Your Ref: OWPC15502
Our Ref: FG/116/17/PL 18-07-2017
Please ask for:
Mr D Easton

Change of height of roof light, removal of high level window on south elevation & erection of 2 No. vent pipes (amendment to FG/99/16/PL).

Ferring Dental Surgery 70 Ferring Street Ferring

GREY ASSOCIATES		
HEMBURY HOUSE JUBILEE ROAD TOTNES TQ9 5BP		
TEL 01803 863097 EMAIL INFO@GREYASSOC.CO.UK		
CLIENT	DR PETER SANER	
TITLE	FERRING DENTAL PRACTICE	
DRAWING	PROPOSED PLAN & ELEVATIONS	
DATE	26.06.16	SCALE 1:100
DRAWING No.	FDP/023/16	
REVISION	B

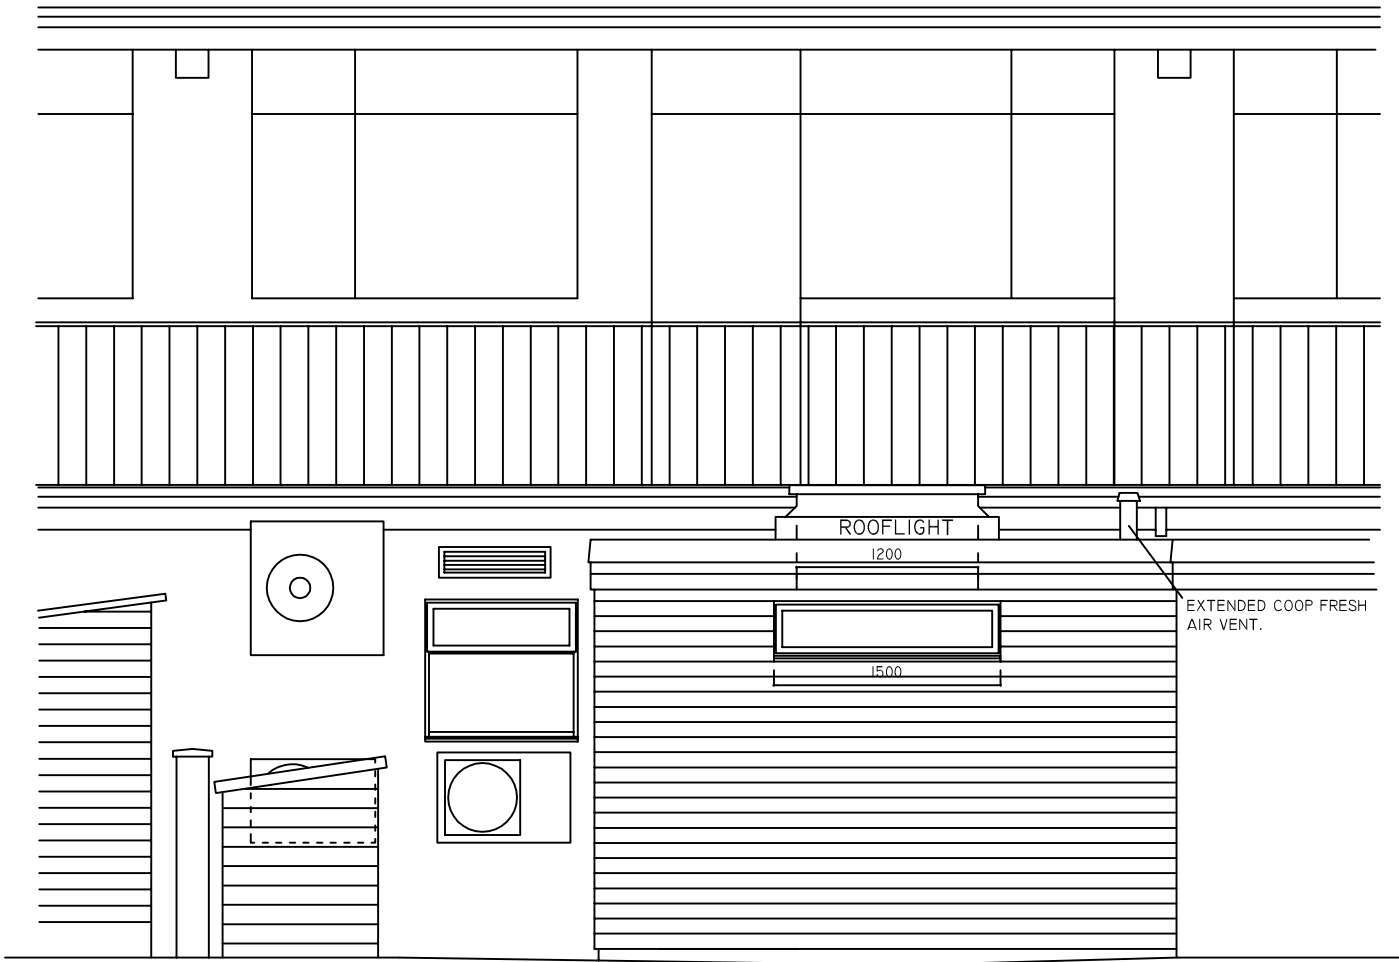
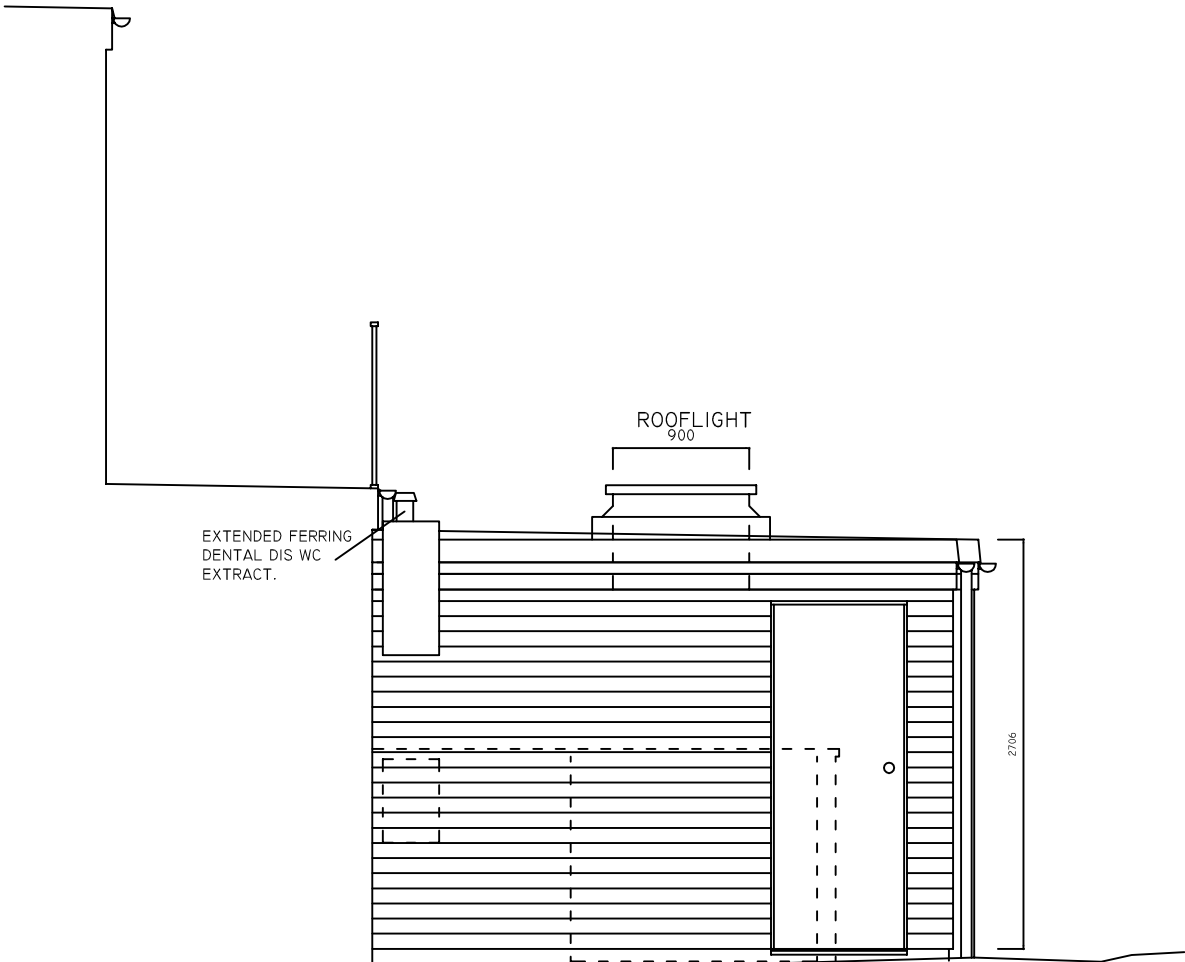
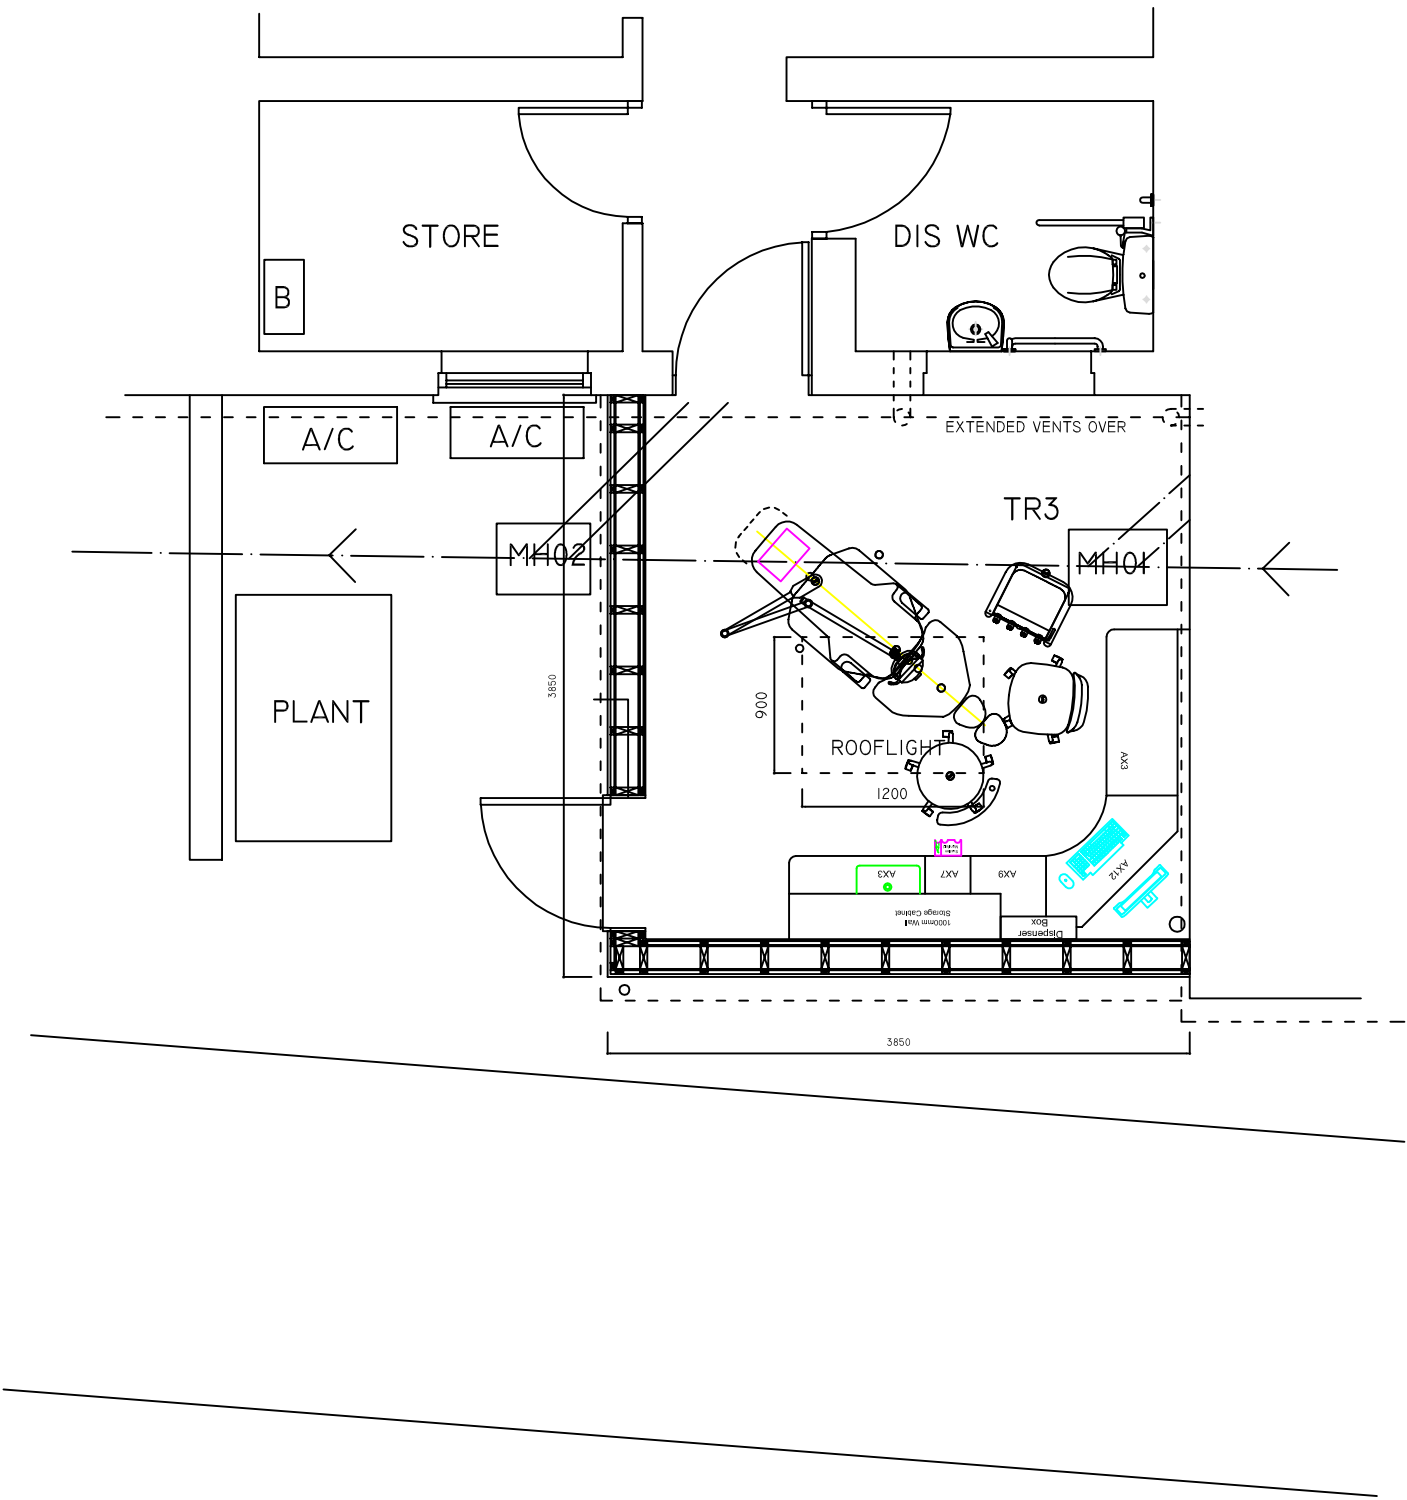
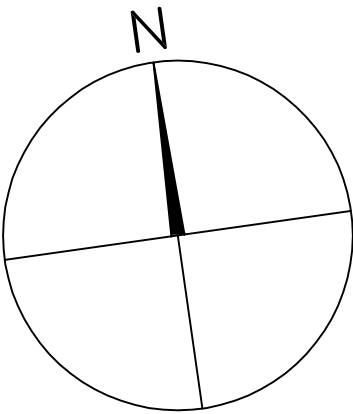
I see this skylight every day from my kitchen window a view I used to enjoy but now get glare from the skylight glass when sunny or wet weather. Health and safety concern me on x-ray leakage as the sides of the skylight are taped in with roofers tape. Also look awful.

Vents are again directly outside my flat where I used to sit. not sure if its safe to sit there now one vent being a toilet vent. Bad planning and unnesercary.

Staff have entered onto walkway to clean said skylight???//

south side window I understand is fixed and does not open so no issue with this.
